Please ask for: Sian Eggington
Email: sian.eggington@terraquest.co.uk
Telephone: 0121 234 1390
Our Ref: R/294/21/HH
Your Ref:
Date: 13th December 2021

Application for Planning Permission for Works or Extension to a Dwelling

Development: Proposed Ground Floor Rear Extension, Loft Conversion with Dormer
Location: 8 Botany Close Rustington BN16 2BJ

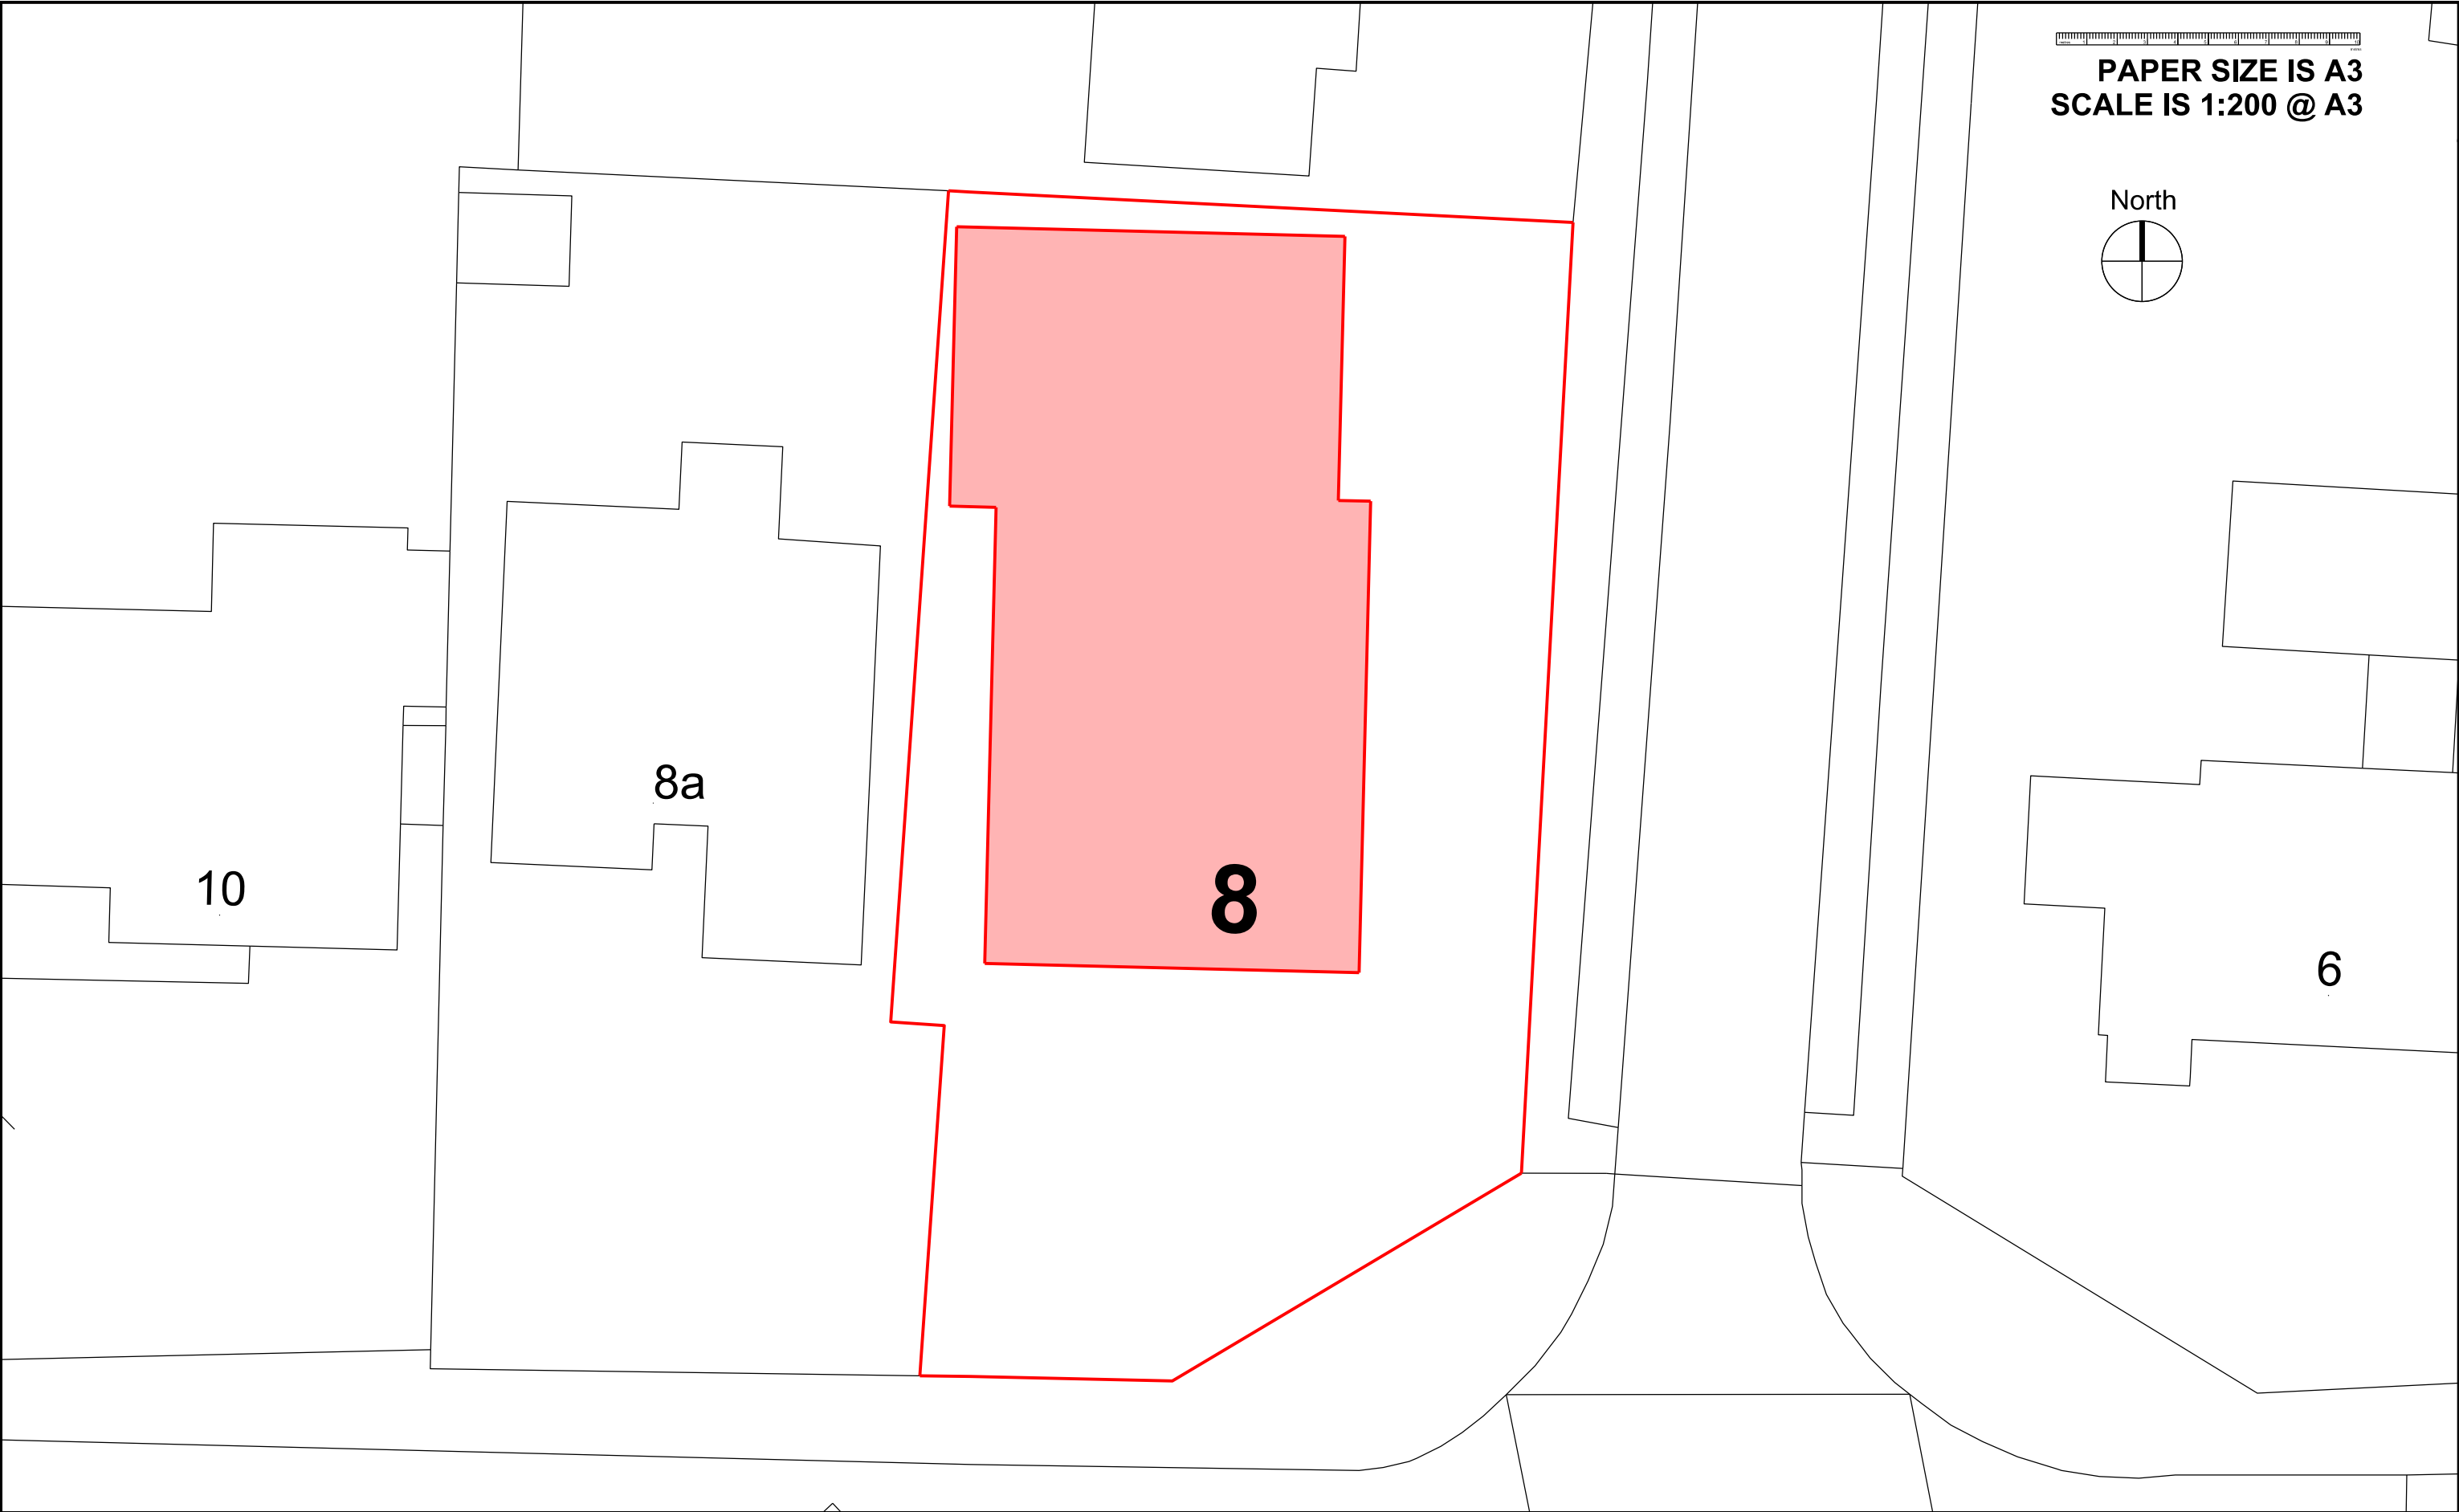
Dimensions: You are required to include dimensions from the proposed extension(s) to all site boundaries. Please amend
